# **Sheringham Shoal and Dudgeon Offshore Wind Farm Extension Projects**

**Draft Statement of Common Ground with National  
Highways (Revision D)**

Title:	
<b>Sheringham Shoal and Dudgeon Offshore Wind Farm Extension Projects Draft Statement of Common Ground with National Highways (Revision D)</b>	
PINS Document no.: 12.22	
Document no.: C282-RH-Z-GA-00219	
Revision: D	
Date:	Classification
<b>July 2023</b>	<b>Draft</b>
Prepared by:	
<b>Royal HaskoningDHV</b>	
Approved by:	Date:
<b>Sheery Atkins, Equinor</b>	July 2023

TITLE  
A47 EASTON  
DRAFT  
ACC47 ACCESS DESIGN  
(SHEET 1 OF 2)

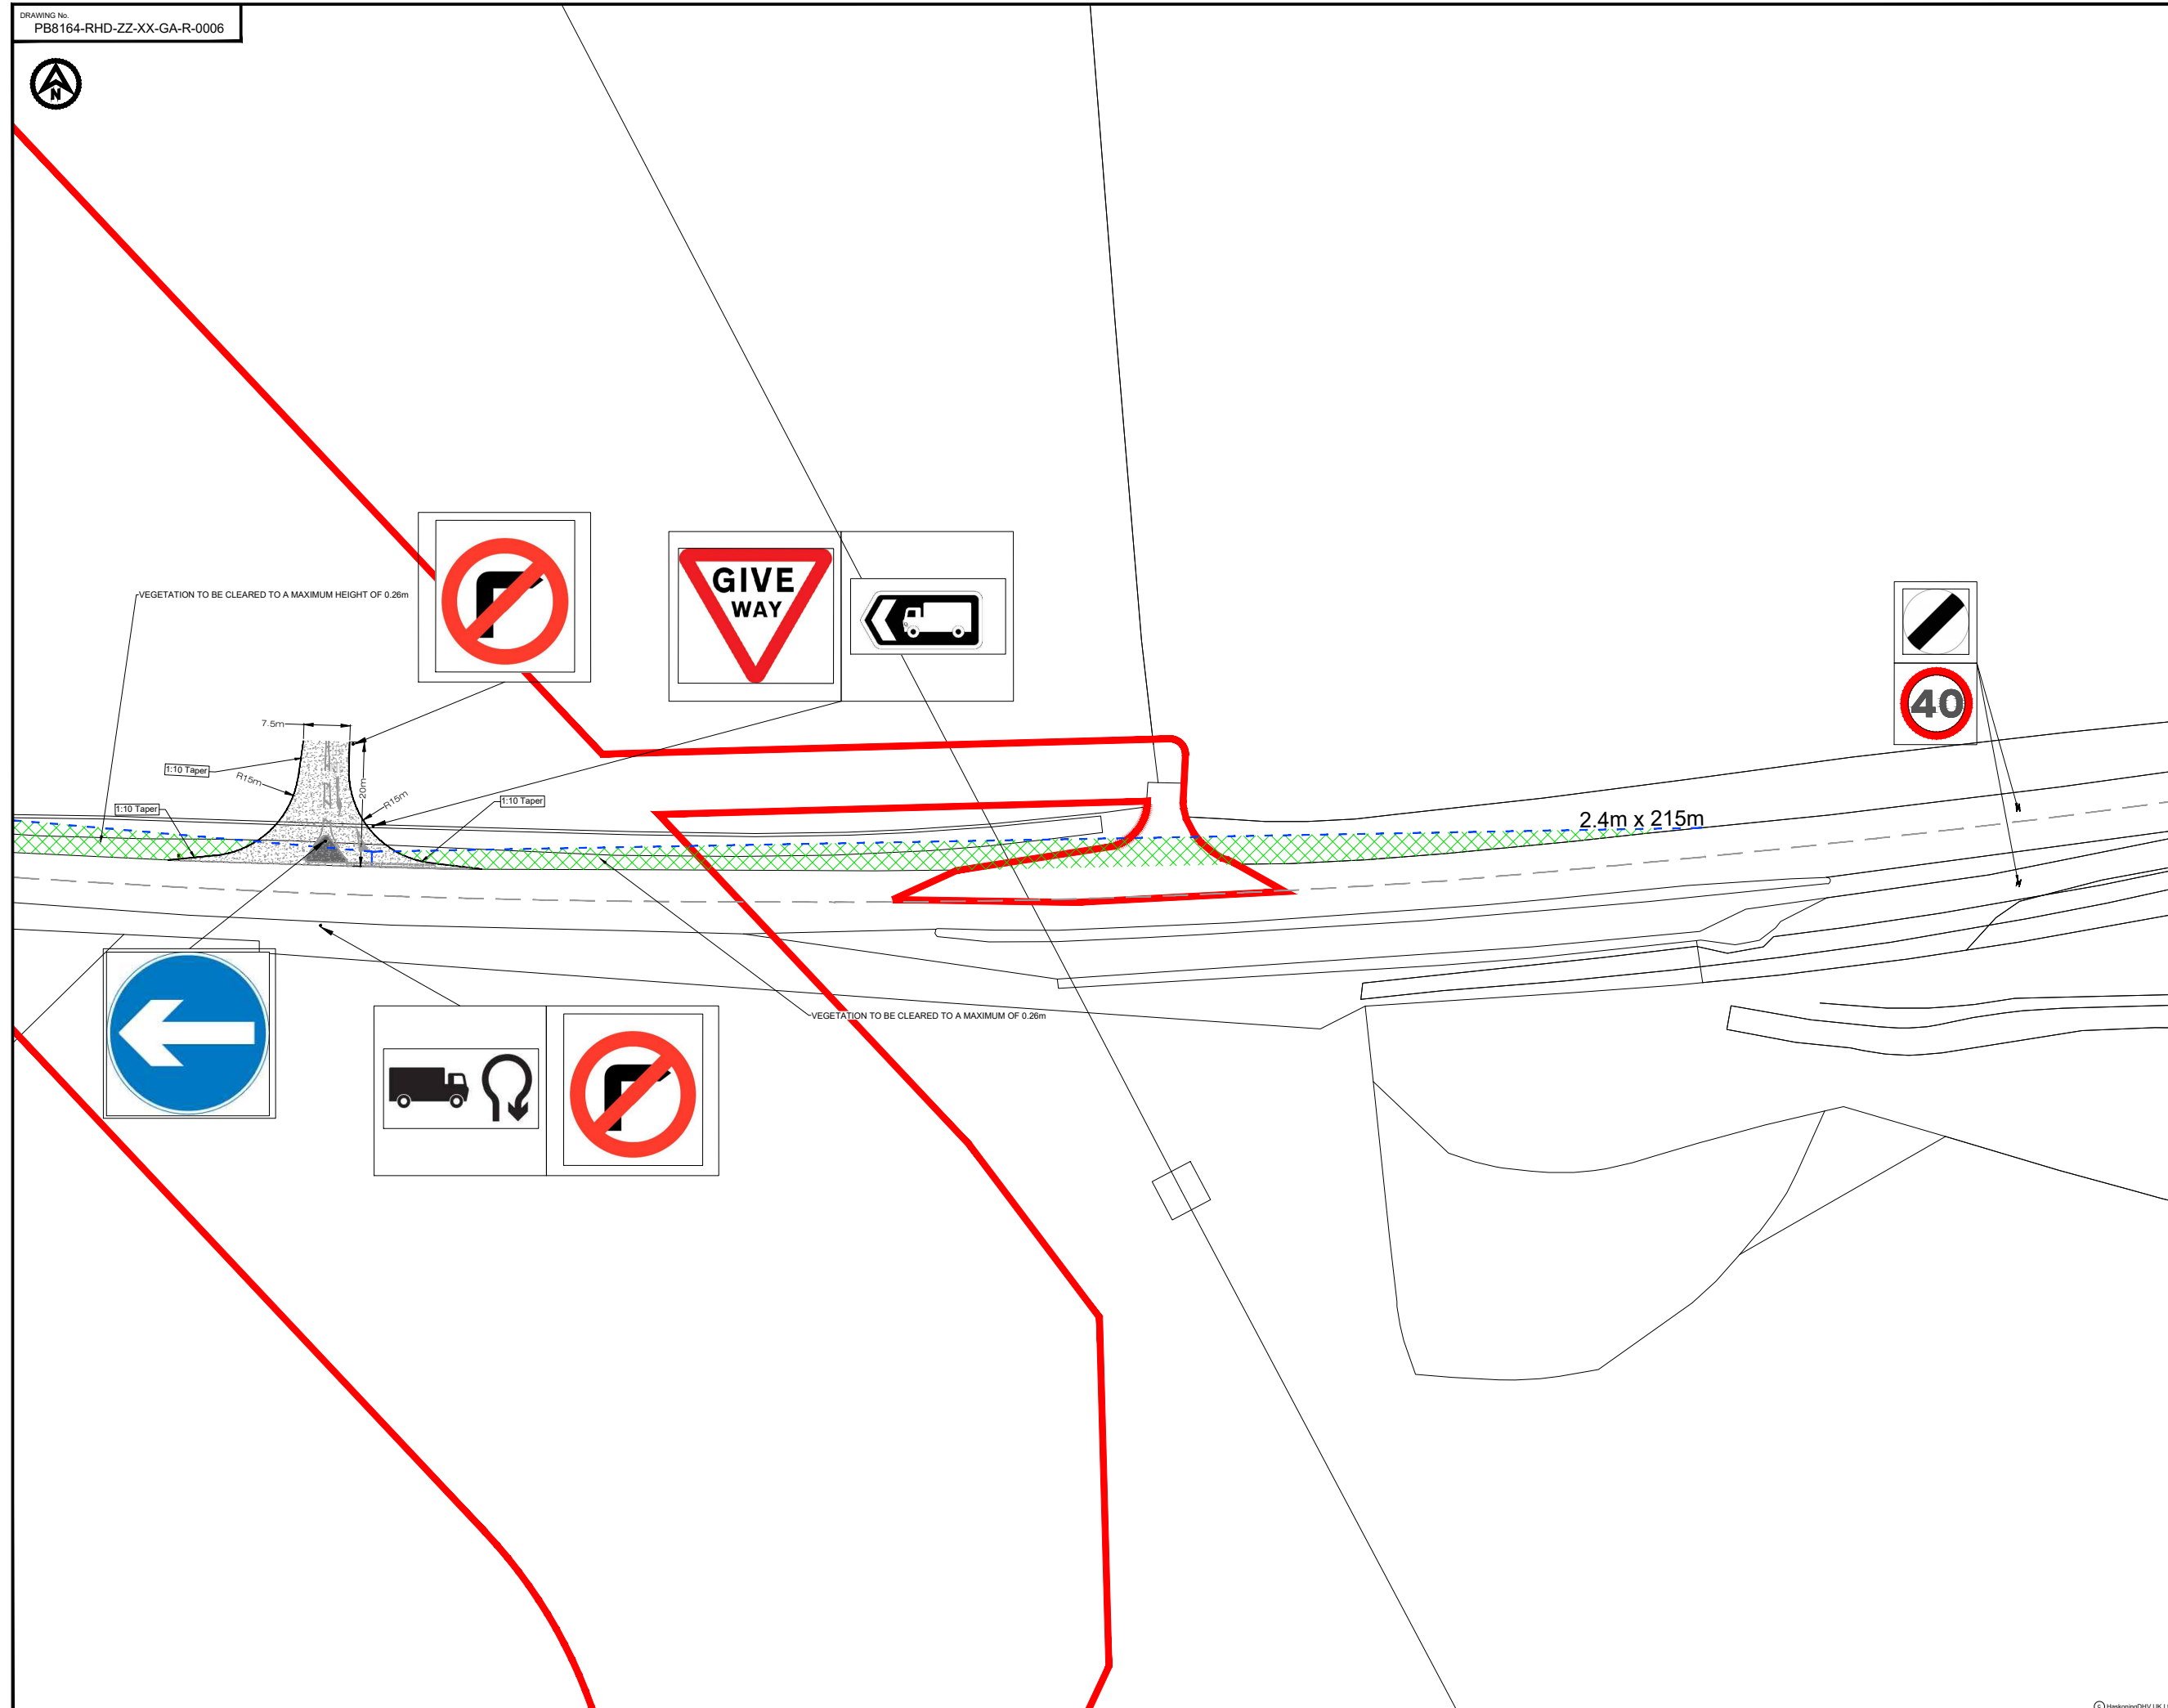
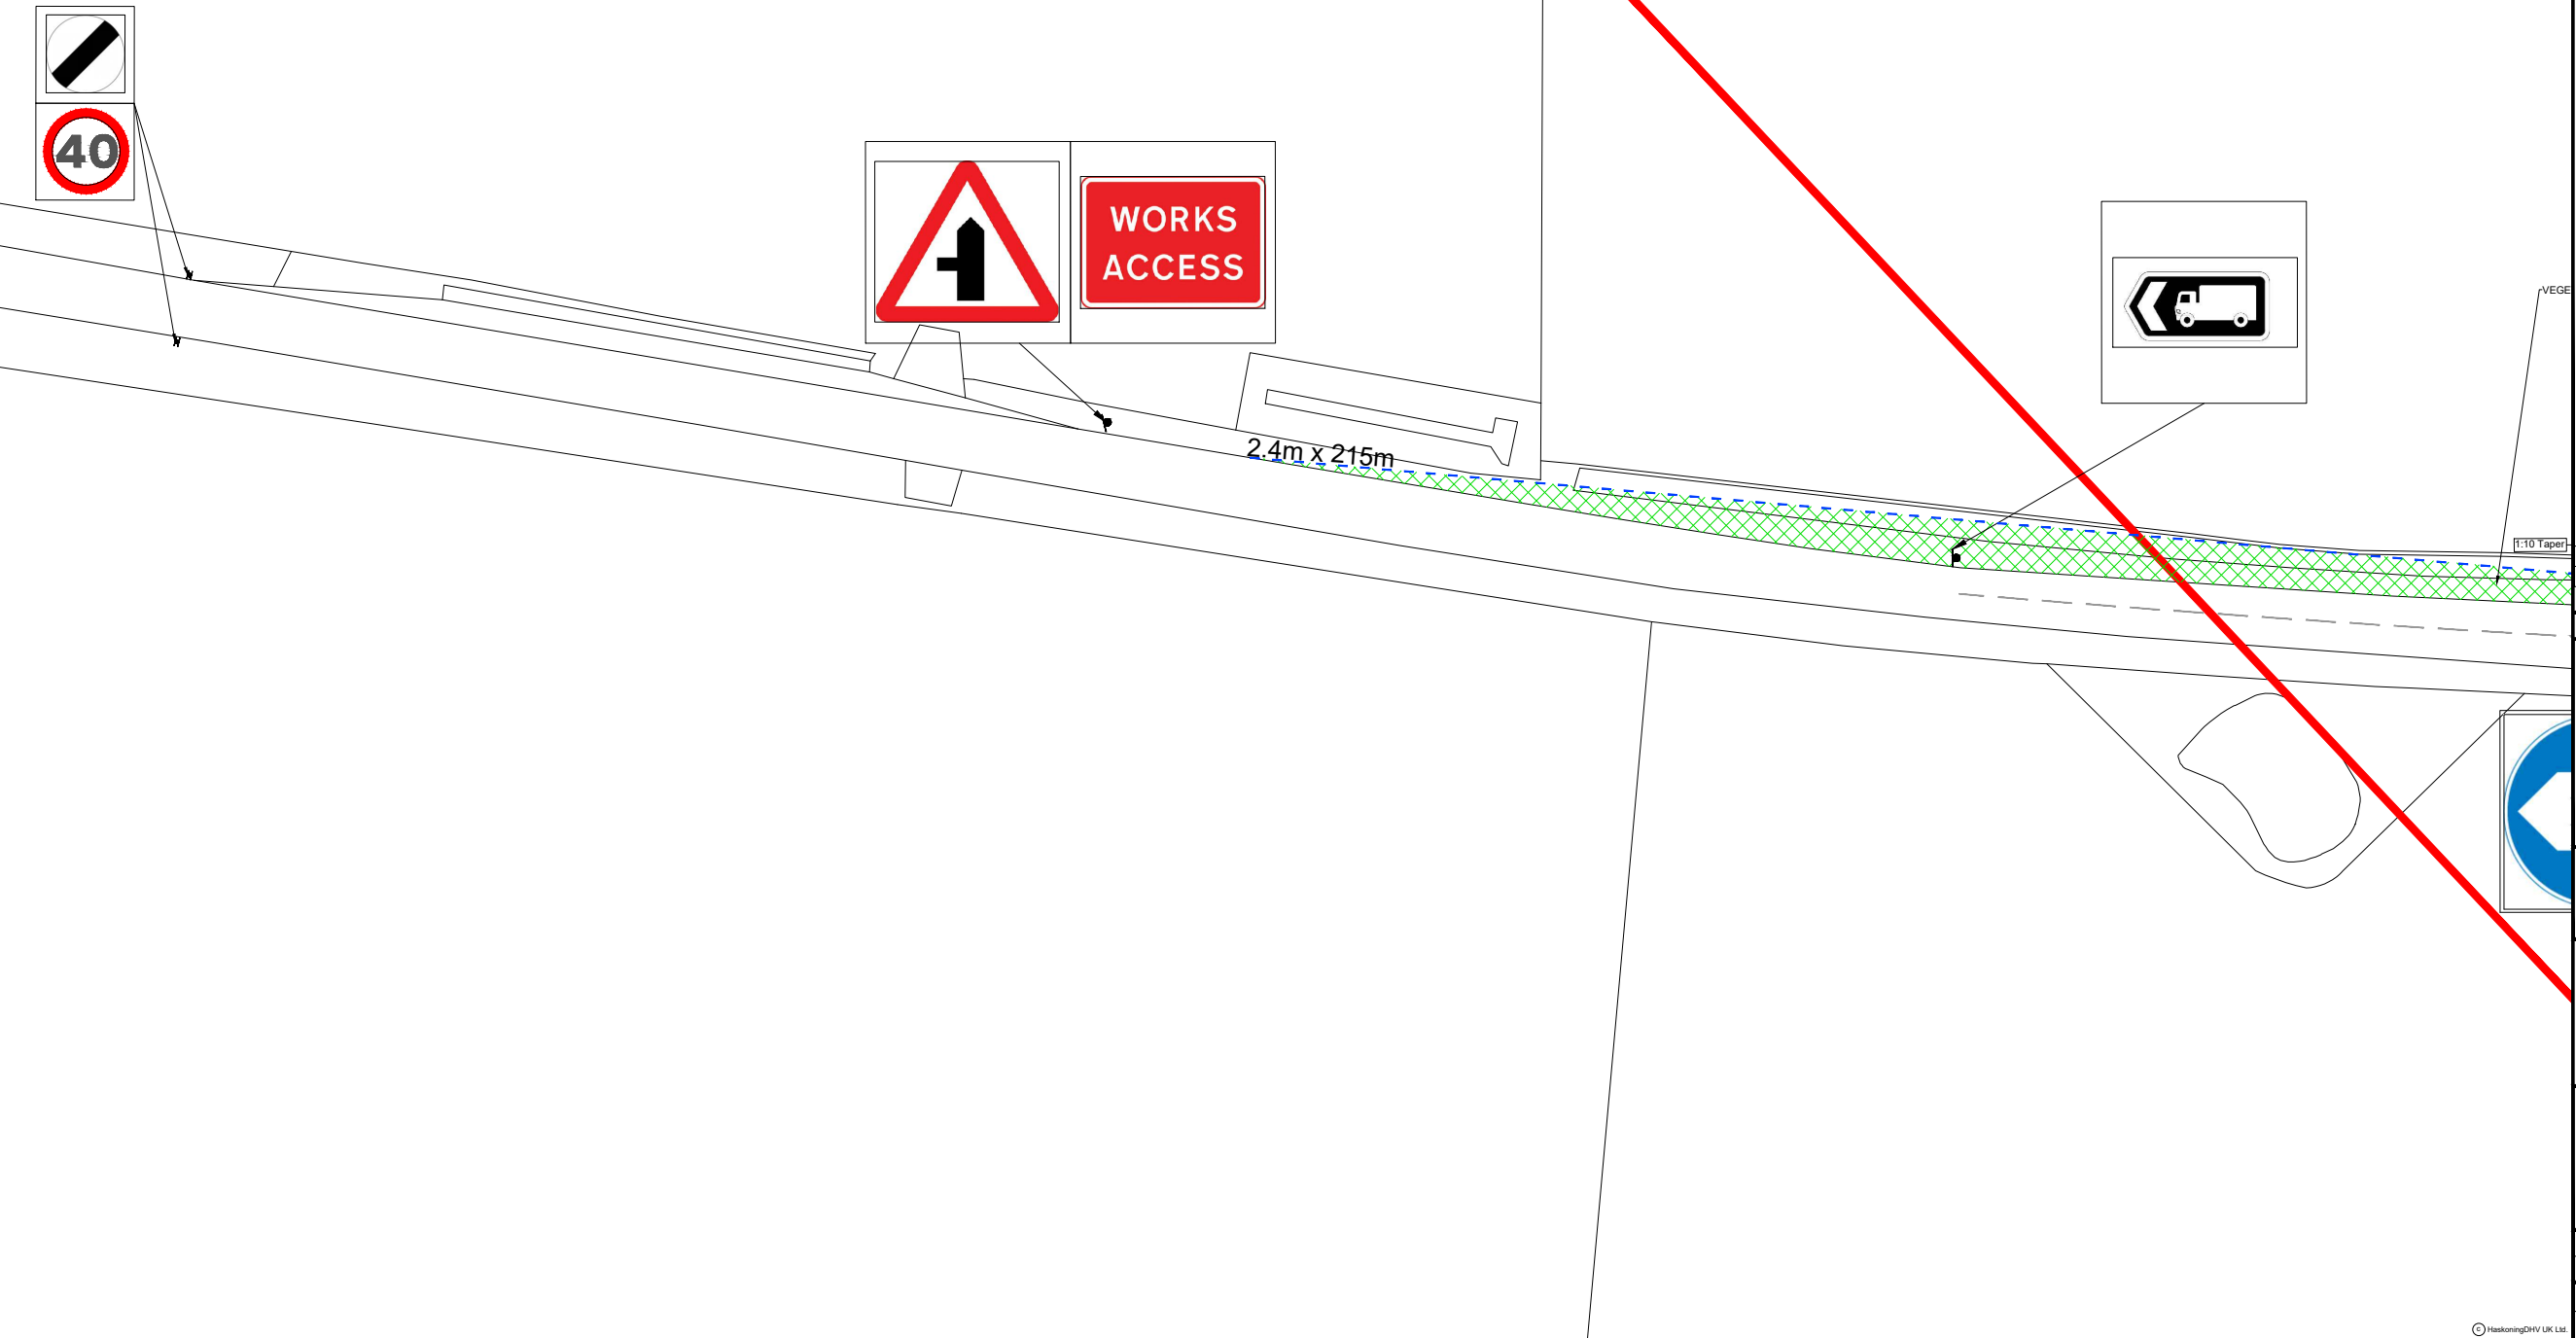
23	The outline design for an access off the A47 is appropriate, as presented in Annex 30 of the Transport Assessment [APP-268 and APP-269]	National Highways agree that the outline design for an access off the A47 (ACC47) is appropriate subject to Stage 1 and 2 Road Safety Audits being carried out post consent. Please note that this access is only usable until the A47 Tuddenham scheme starts construction, or if the A47 Scheme does not go ahead.	<i>Agreed</i>
<b>EIA – Cumulative Impact Assessment (CIA) Conclusions</b>			
24	Cumulative impacts assessment with other windfarms, as presented in Section 24.7 of ES Chapter 24 Traffic and Transport [APP-110], is appropriate based on currently available information and proposed mitigation, impacts are not significant in EIA terms.	National Highways agree that the cumulative impacts assessment with other windfarms, in relation to effects on traffic along the SRN, as presented in Section 24.7 of ES Chapter 24 Traffic and Transport [APP-110], is appropriate based on currently available information and proposed mitigation, impacts are not significant in EIA terms.	<i>Agreed</i>

29	The access concept design for access ACC47 is appropriate and that detailed access designs can be developed and agreed with National Highways prior to the start of construction, secured under Requirement 16 of the draft DCO [AS-009].	National Highways agree that the access concept design for access ACC47 is appropriate, subject to Stage 1 and 2 Road Safety Audits to be carried out post consent, and that detailed designs can be developed and agreed with National Highways	<i>Agreed</i>
